From: [Jeremy Larson](#)
To: [Rachael Stevie \(CD\)](#)
Subject: RE: SE-22-00014 Tapert - Notice of Application
Date: Thursday, April 21, 2022 11:27:04 AM
Attachments: [image001.png](#)
[image004.png](#)
[image005.png](#)
[image006.png](#)

**ARCHITECTURAL SITE PLAN**

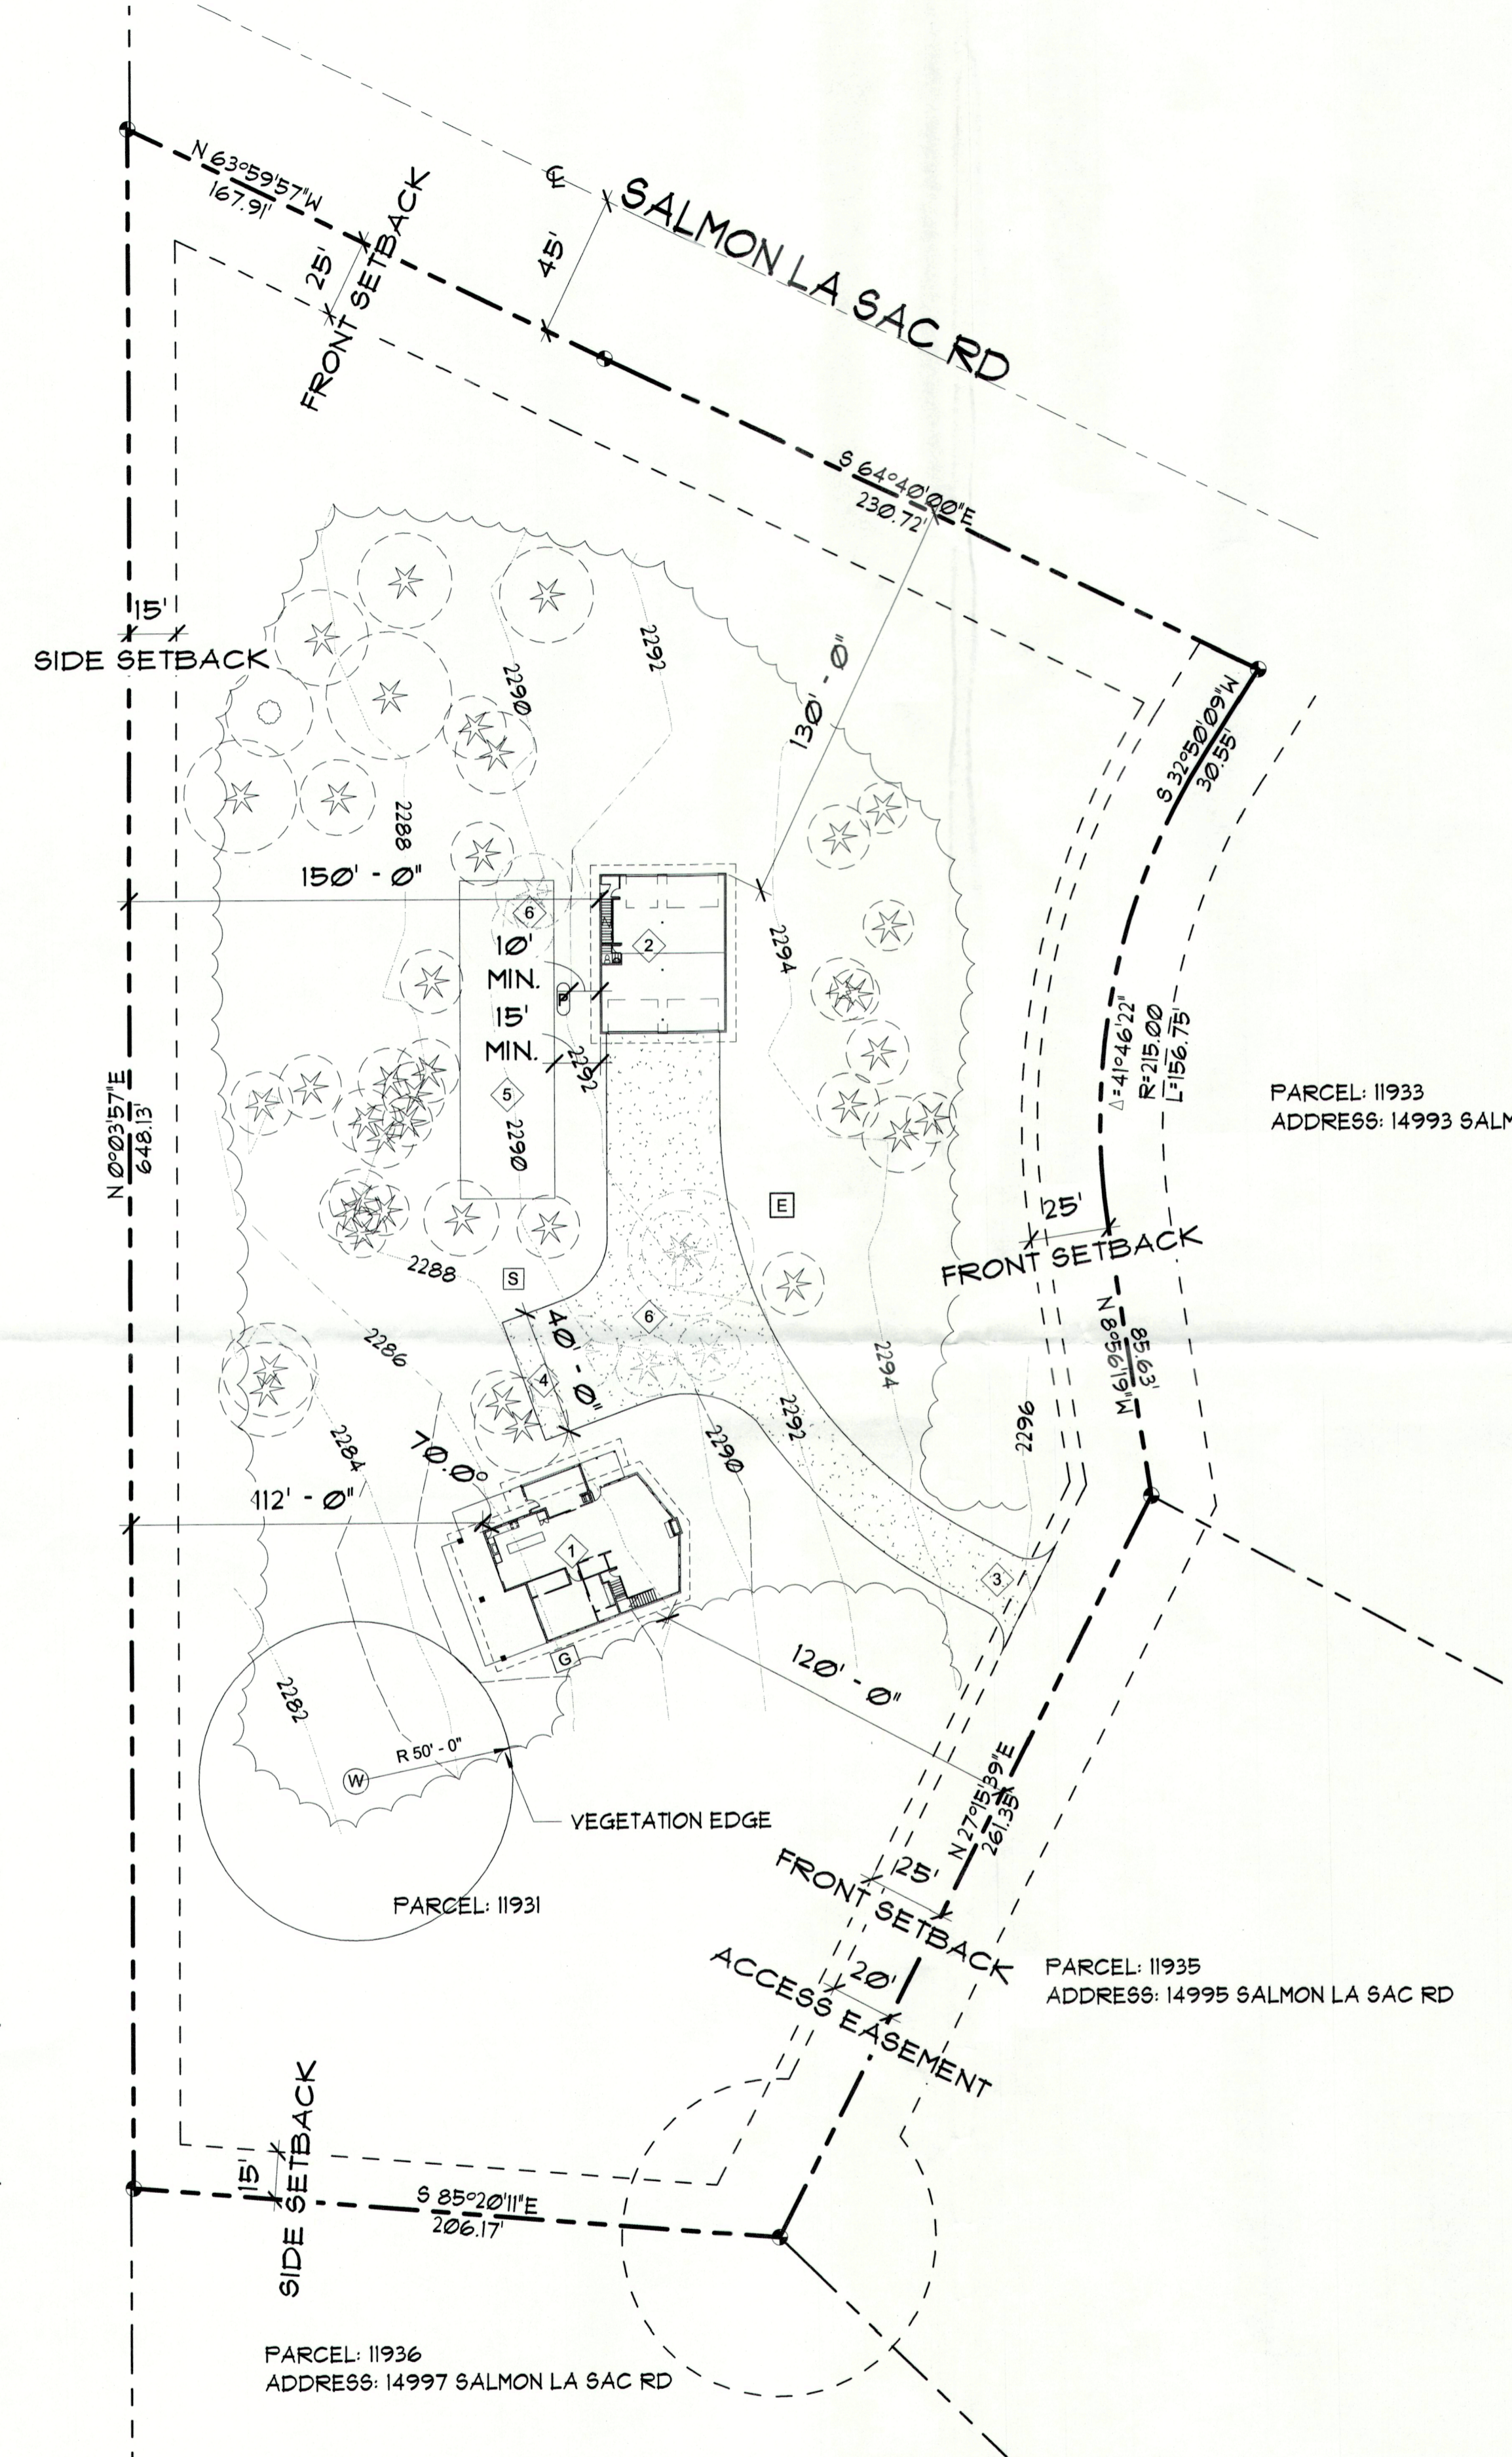
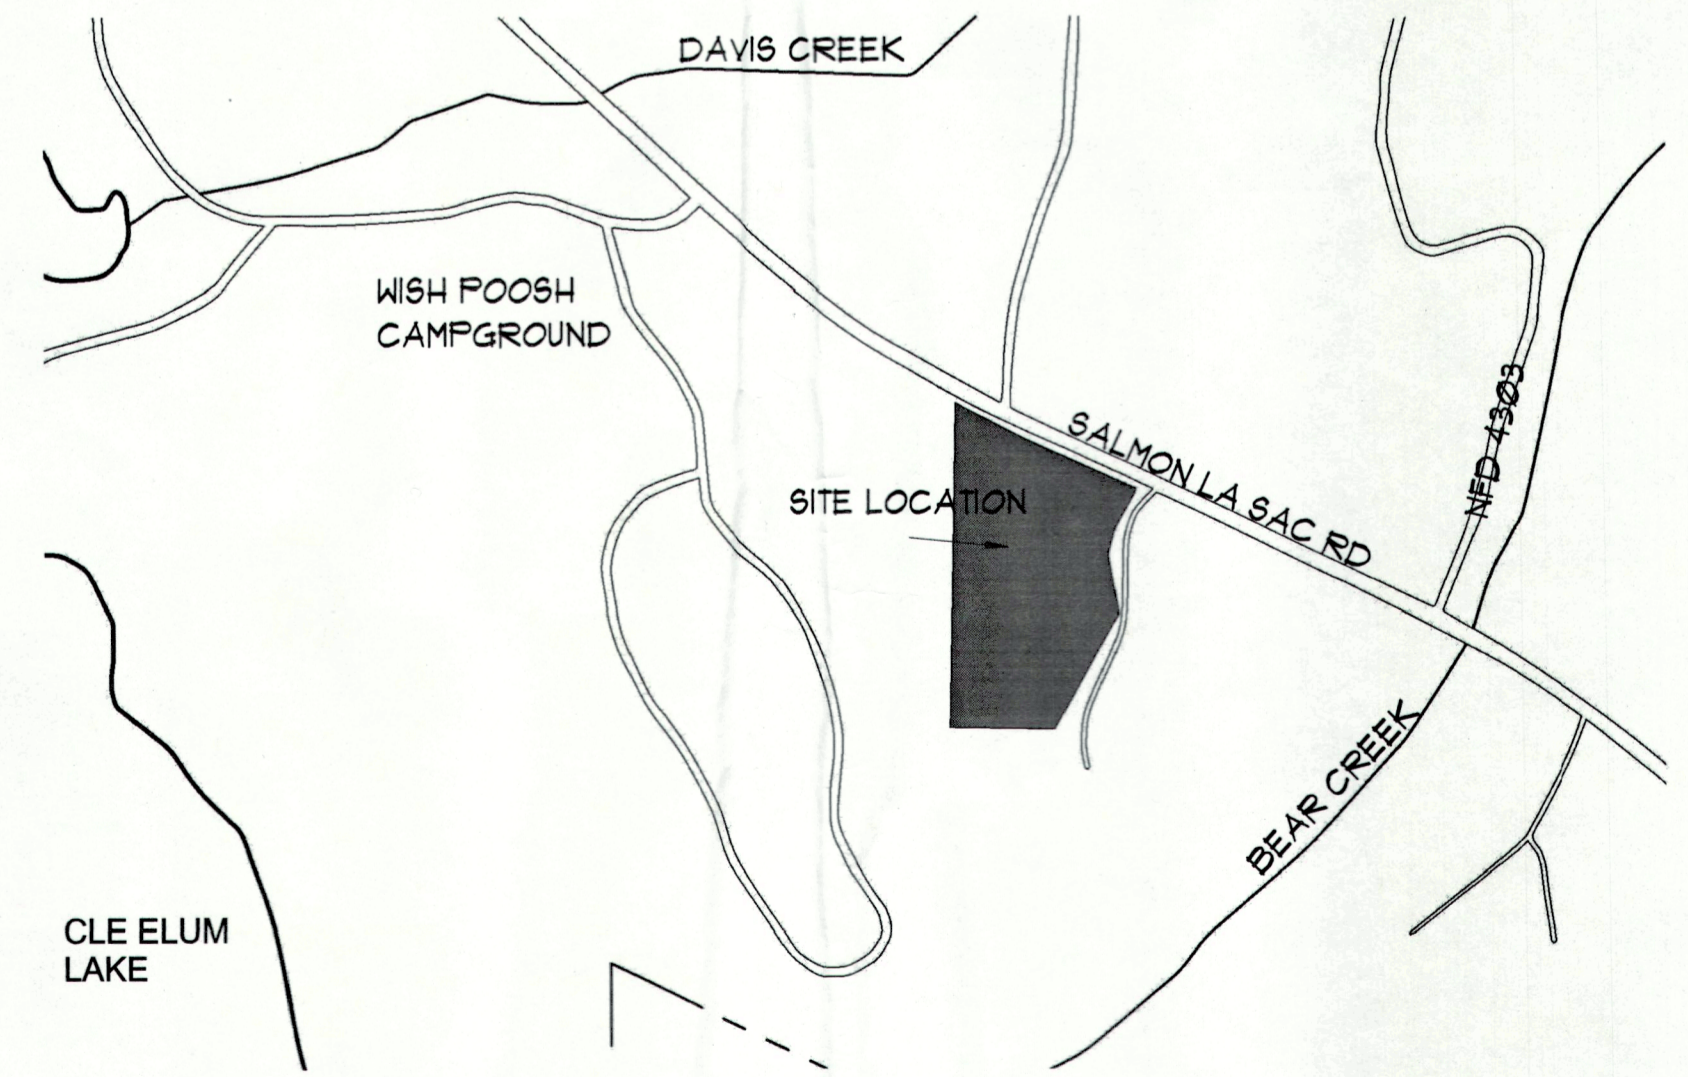
I don't have any comments on the Building side of the project but I did notice on the site plan that a separate guest house/ guest dwelling is noted under the Project Data and Site Plan Keynote #2. I checked on Compas and this parcel appears to be in a Rural Recreation zone with a 5 acre minimum lot size. Since the lot is only 4 acres I don't believe a separate dwelling (or ADU) would be allowed. I must defer to Planning on this interpretation but thought it should be noted prior to a preliminary site analysis completed.
